Final Report - Corrections Required **Application No. LUPL-25-0008**

Document Filename : 241010_BLR Village C Land Use Plan.pdf

BANNING LEWIS RANCH - VILLAGE C
LAND USE PLAN
COLORADO SPRINGS, CO
LAND USE PLAN

Please use this on the coversheet as well.

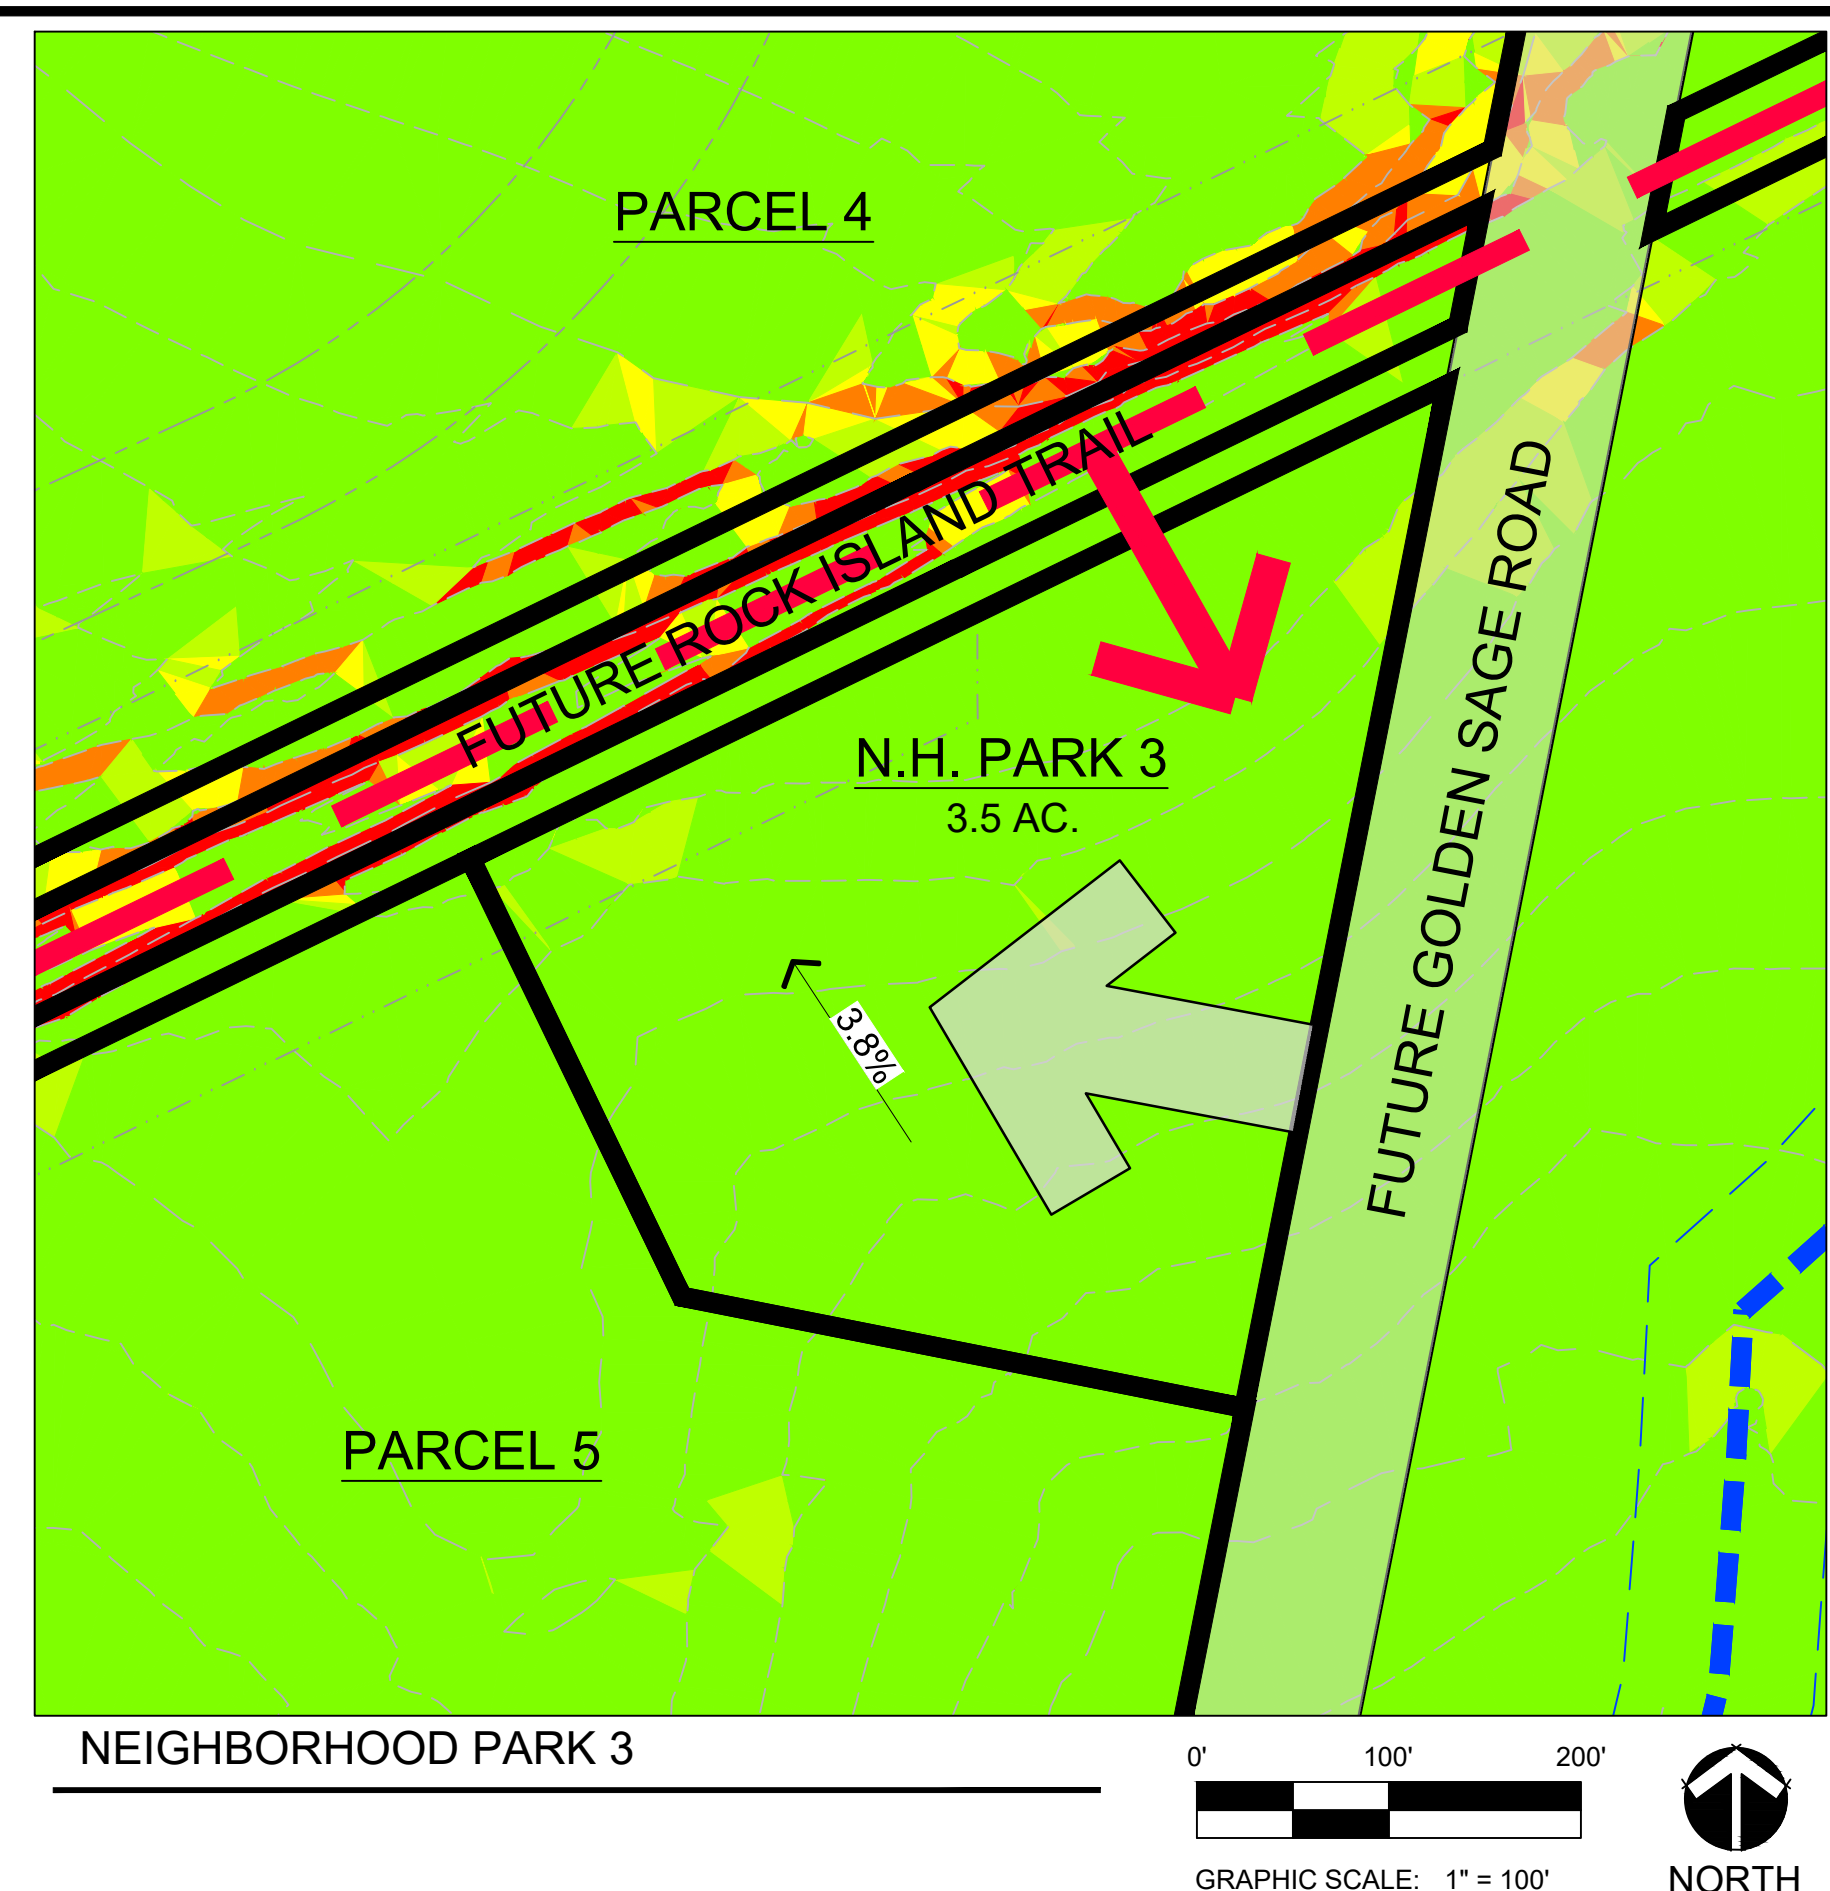
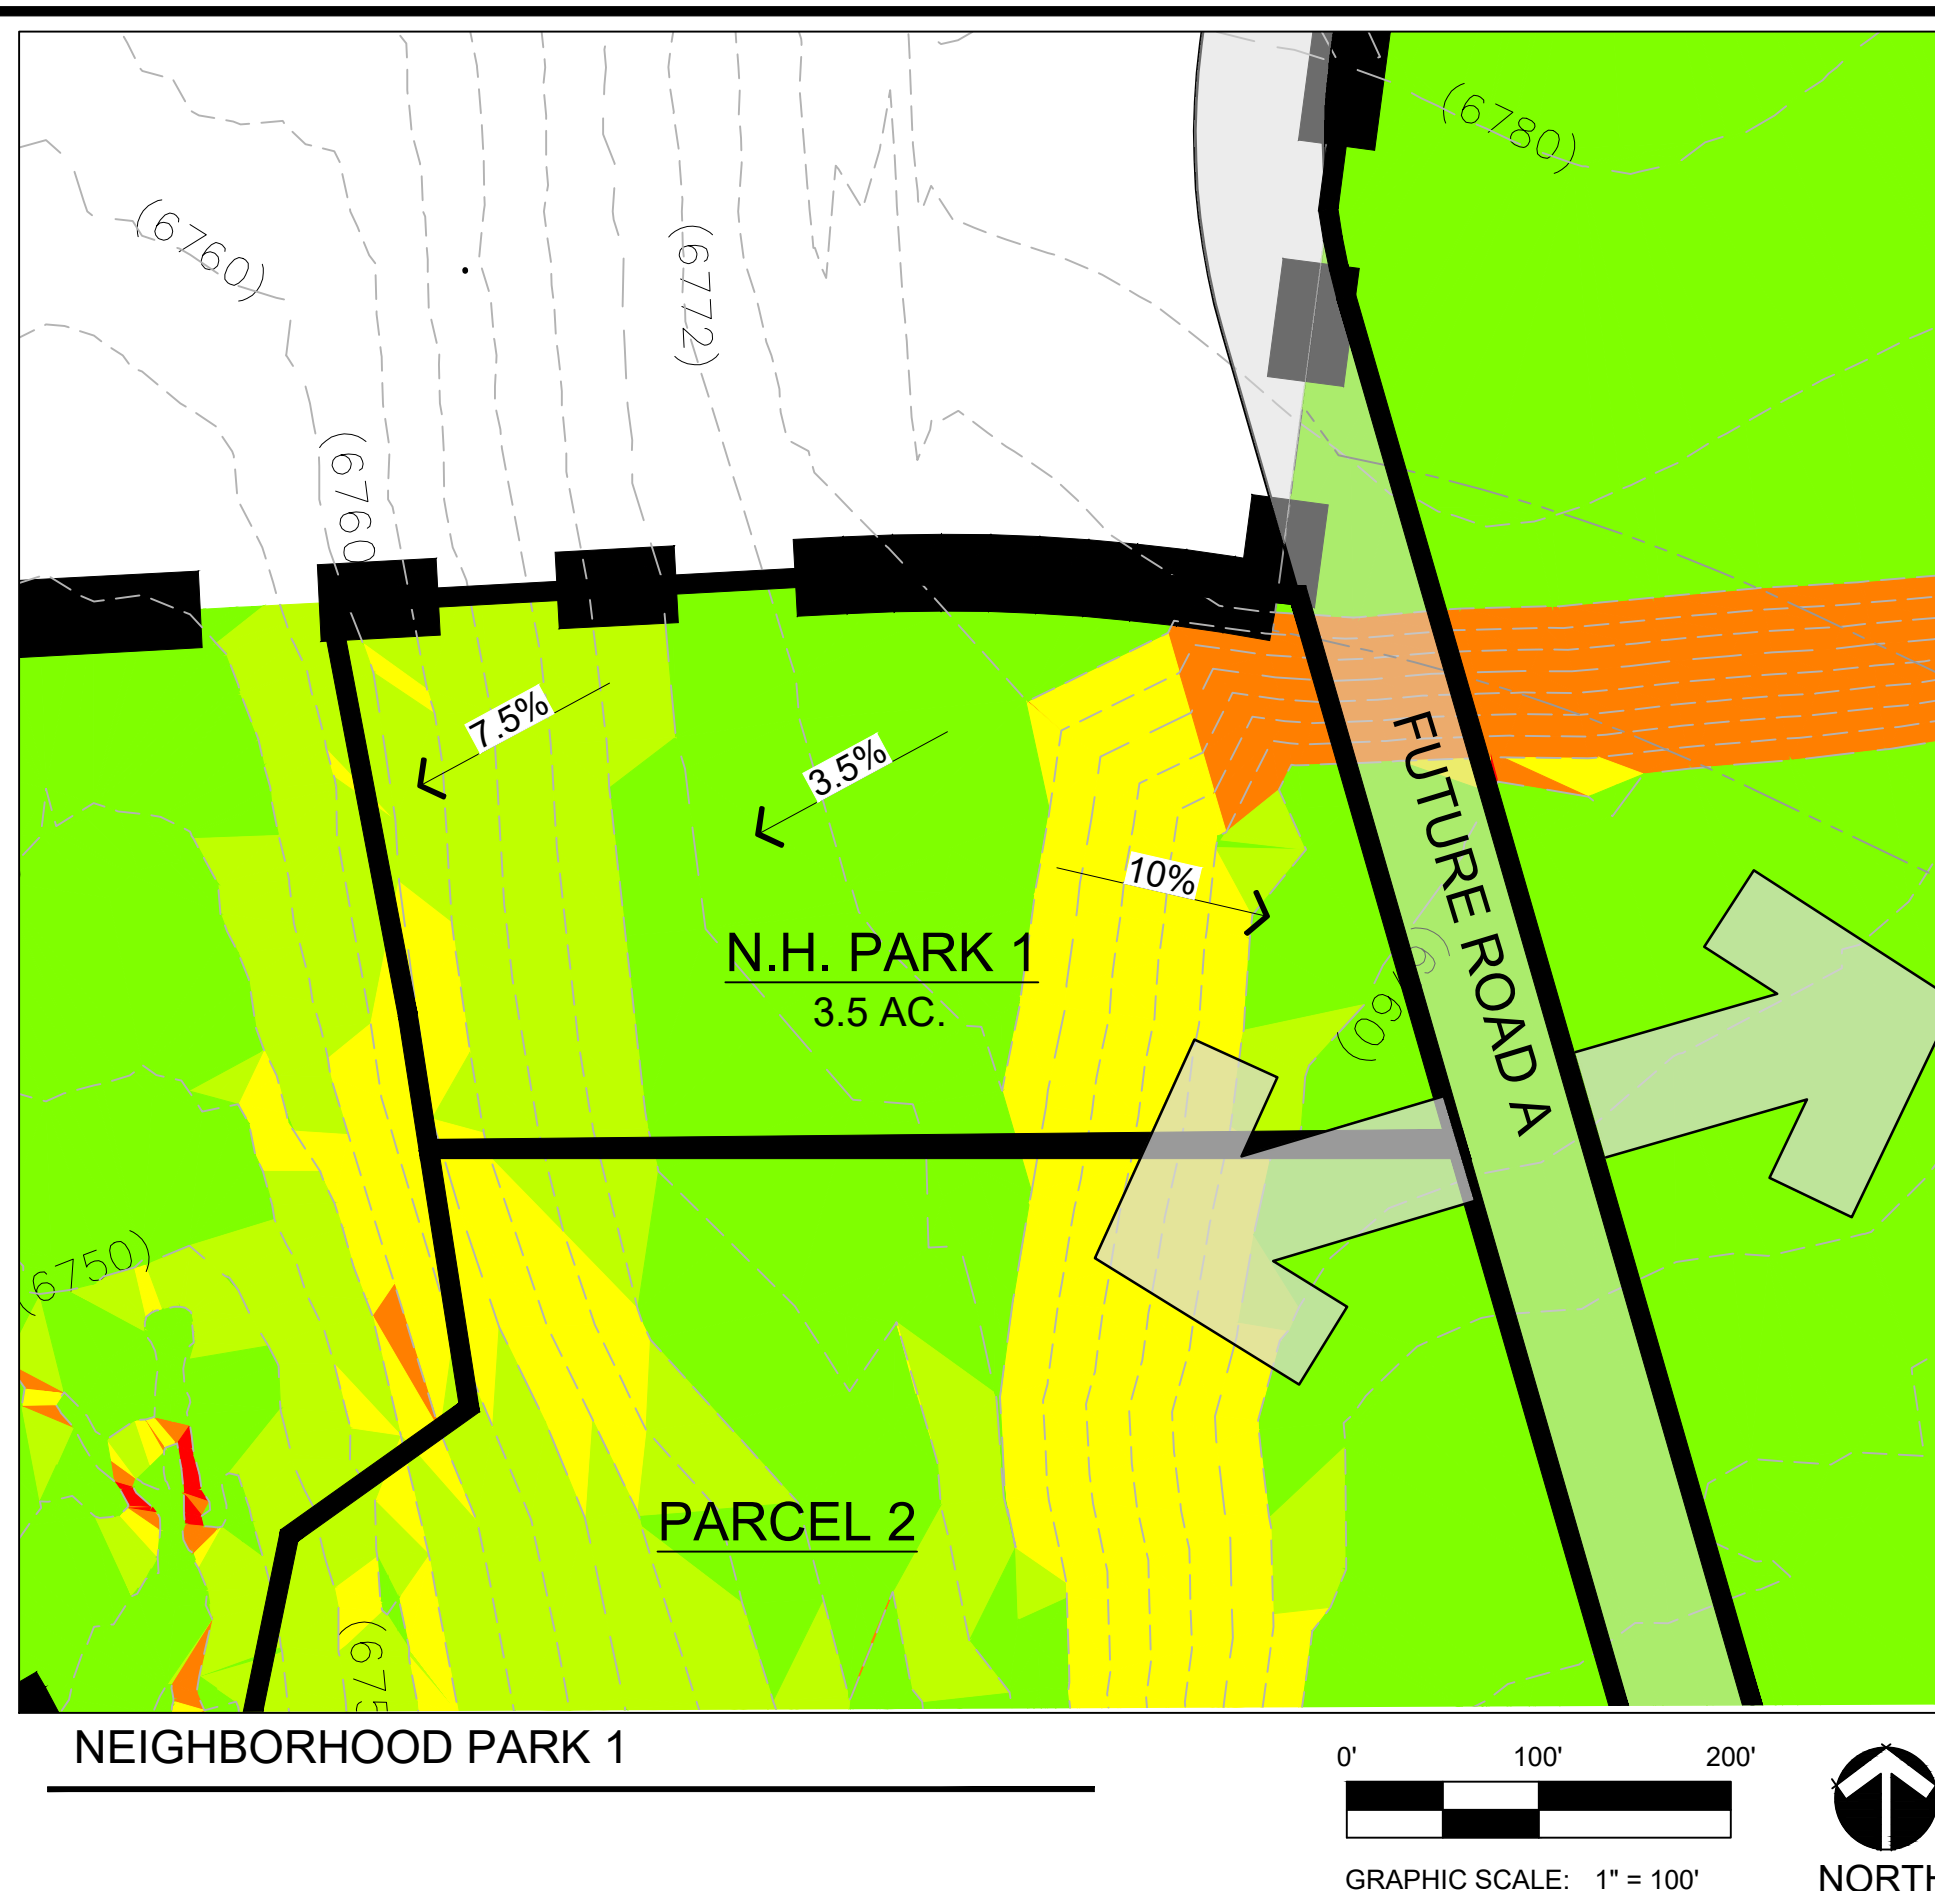
53	2	Tamara Baxter : Planning	Please use this on the coversheet as well.
54	2	Tamara Baxter : Planning	What does this residential encompass?
30	3	Caroline Miller : Planning	This graphic doesn't match the LUP Bubbles shown on page 2, park is not next to Public Safety.
